**Consultation Response from KC,  
Trees**

**2024/93326 Bradley Nursery, Bradley Junction Industrial Estate, Leeds Road, Bradley,  
Huddersfield, HD2 1UR**

**Provision of a temporary compound as part of the Transpennine Route Upgrade Programme**

**Date Responded: 28/01/2025**

Drawing Title
**BRADLEY JUNCTION
COMPOUND SITE
SURFACE FINISHES**

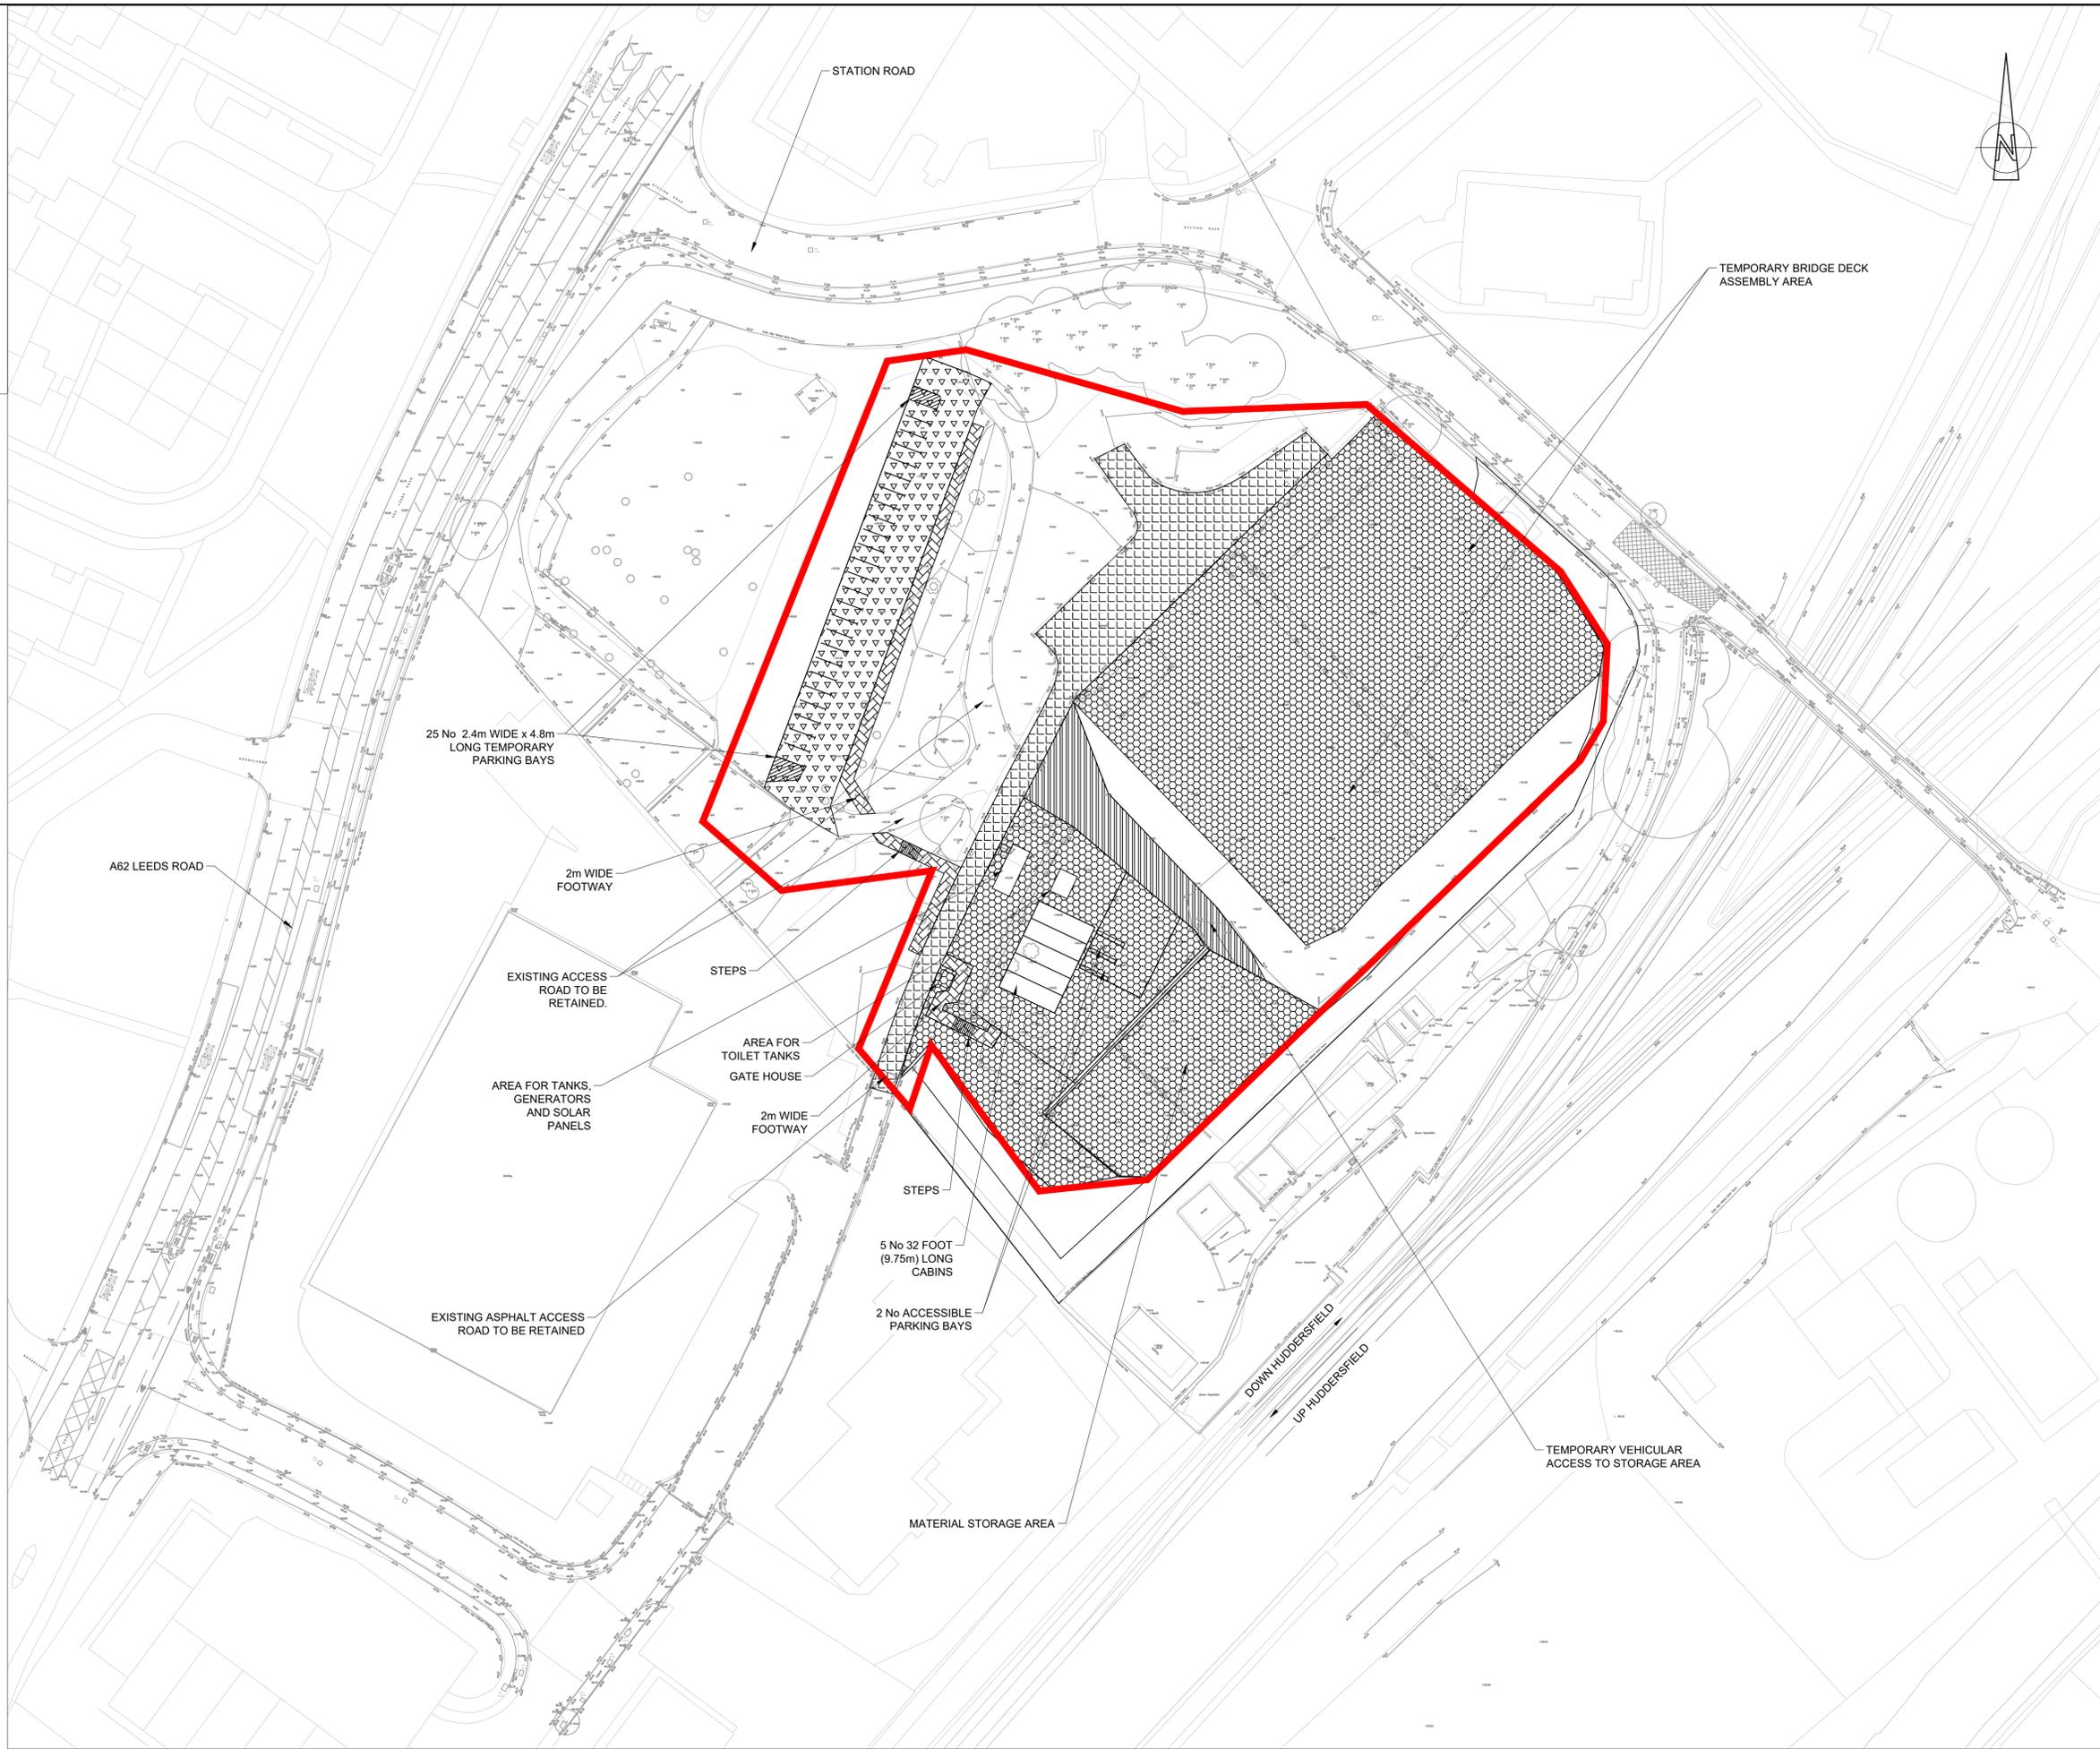
The plans look well planned out and have taken every step to avoid impacts on the surrounding trees. The most significant trees on site are situated towards the northern boundary and all plans but one corner of the temporary car park appear to be outside of the influence zone. The corner of the temporary car park is planned to be a permeable material and therefore shouldn't restrict the trees' ability to gain water.
